# CITY OF ALBUQUERQUE

August 12, 2016

**Re: Dunkin Donuts**  
**2301 Juan Tabo Blvd NE**  
**60-Day Temporary Certificate of Occupancy- Transportation Development**  
Architect's Stamp dated 01-08-16 (XXX-DXXX)  
Certification dated 07-27-16

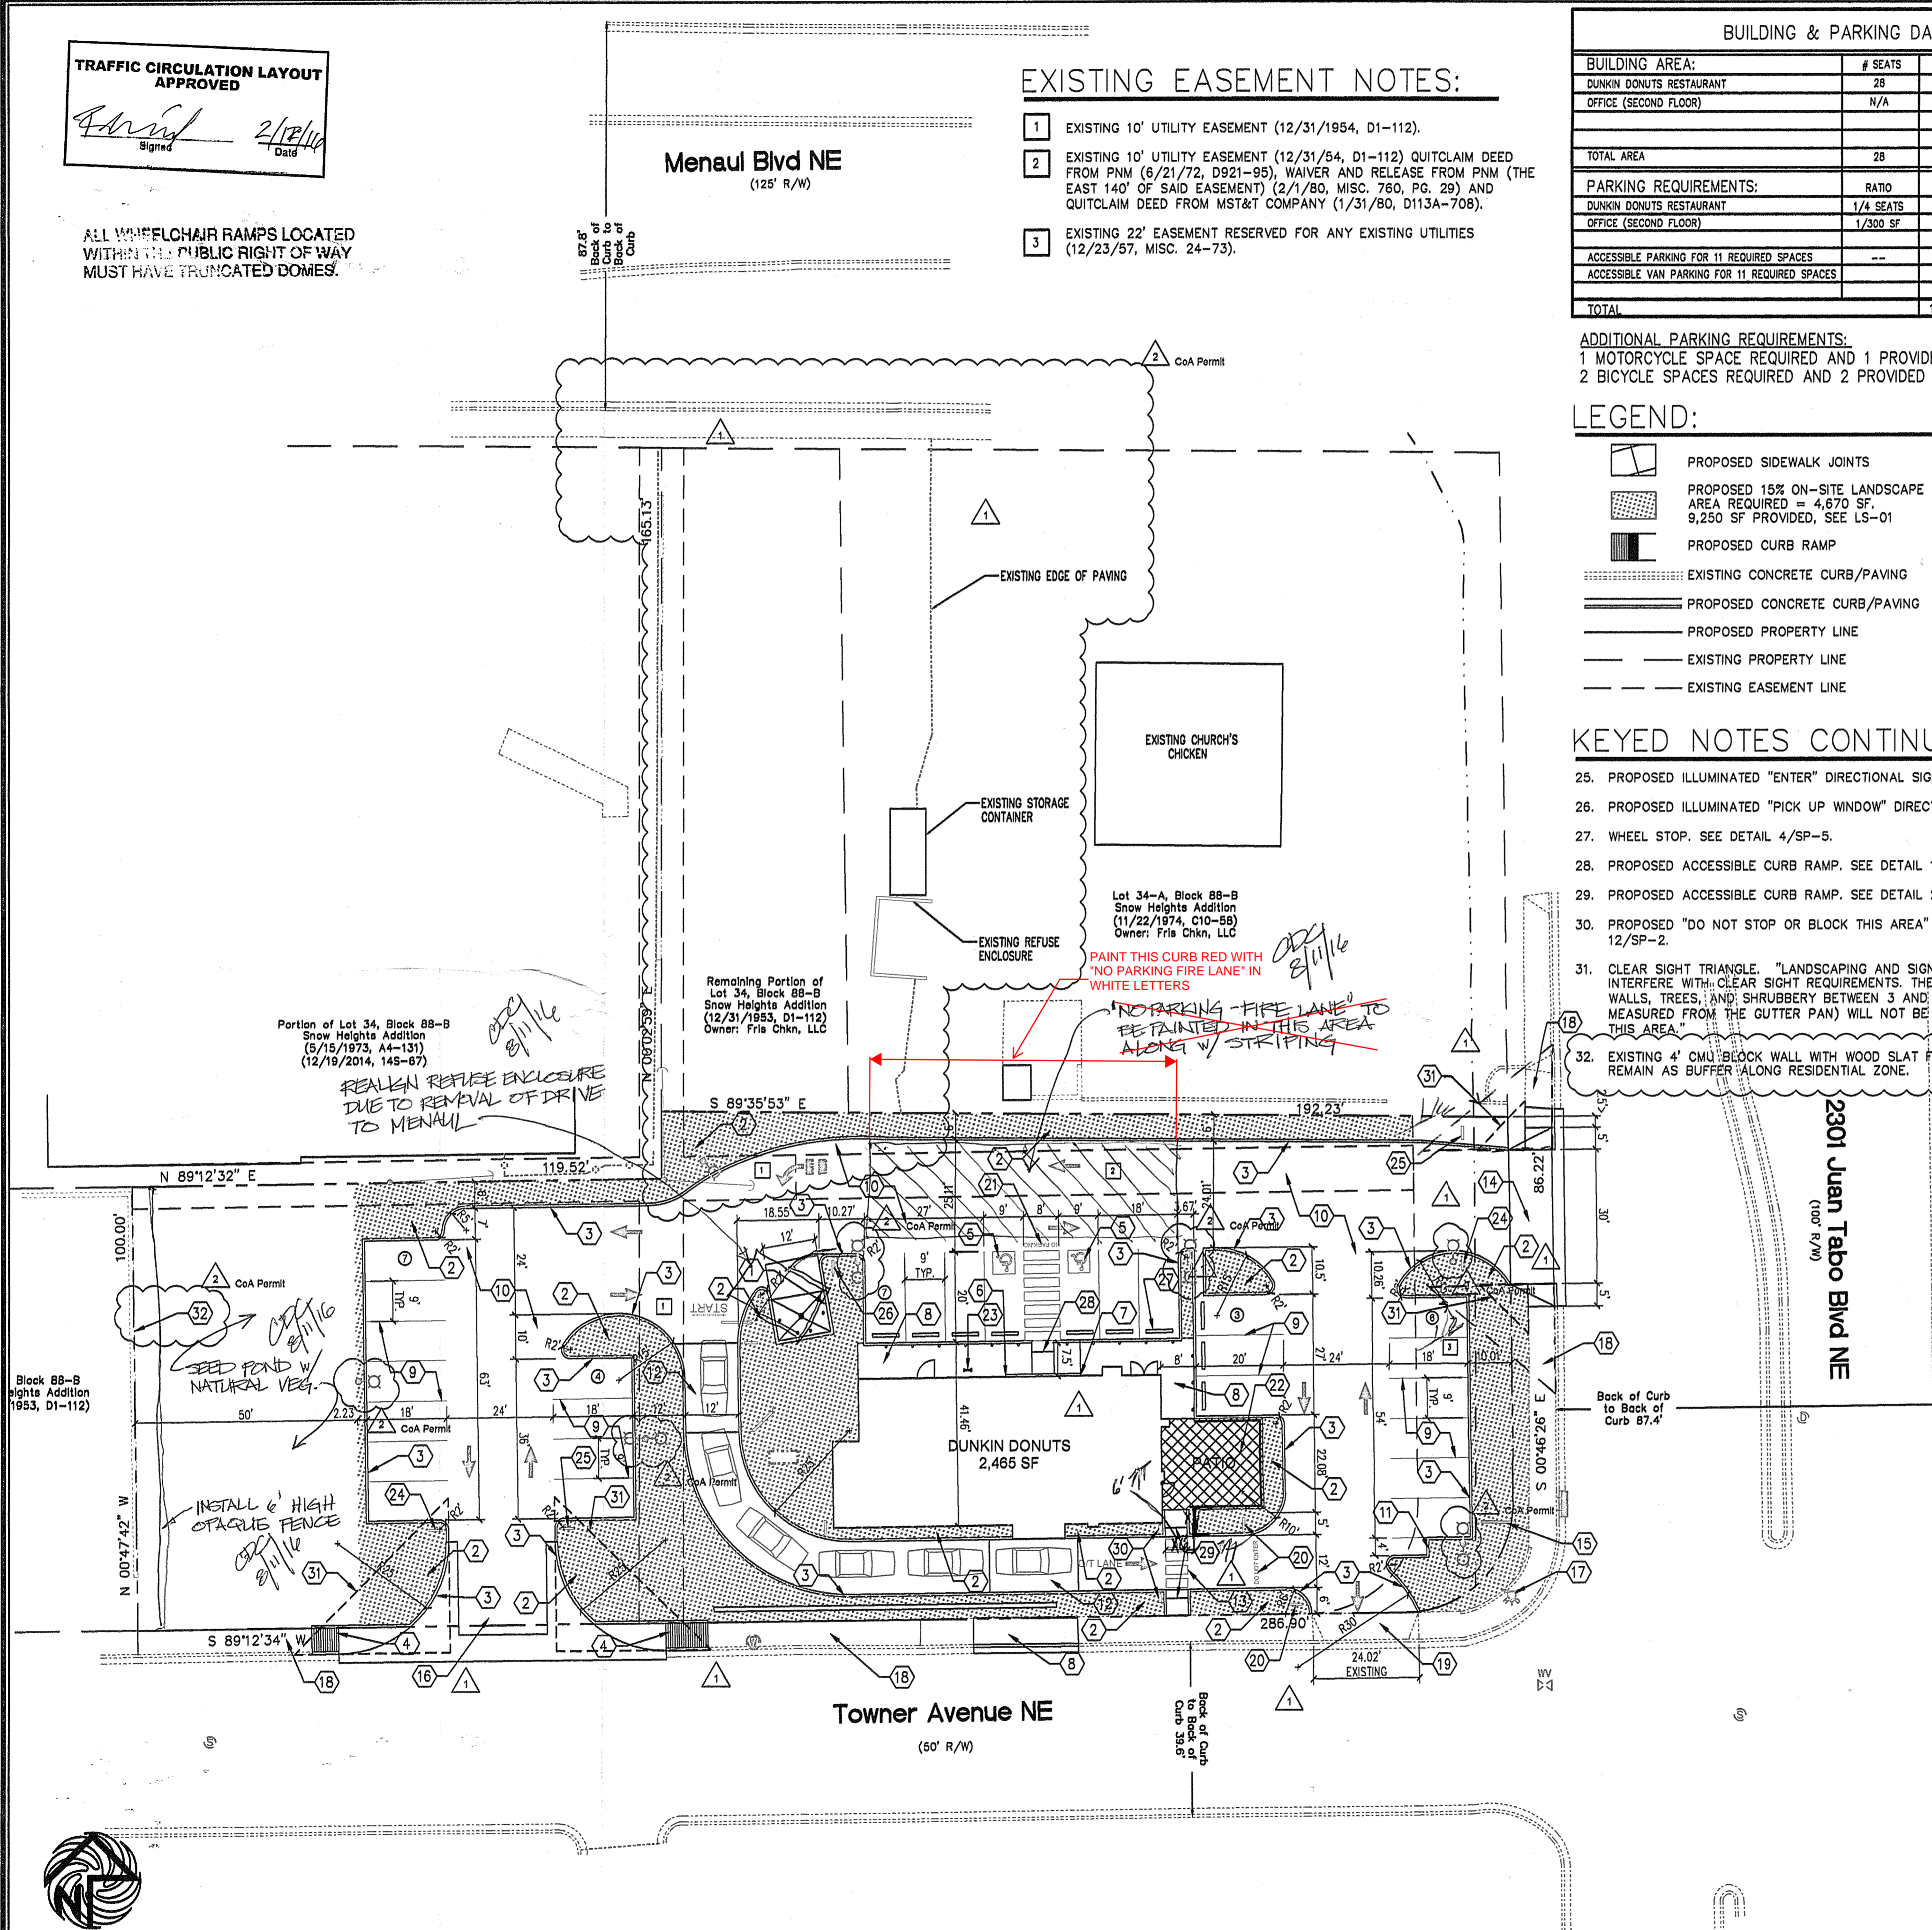
- The header curb on the north end of the property, across from the handicapped parking will need to be painted red with white lettering "No Parking Fire Lane".
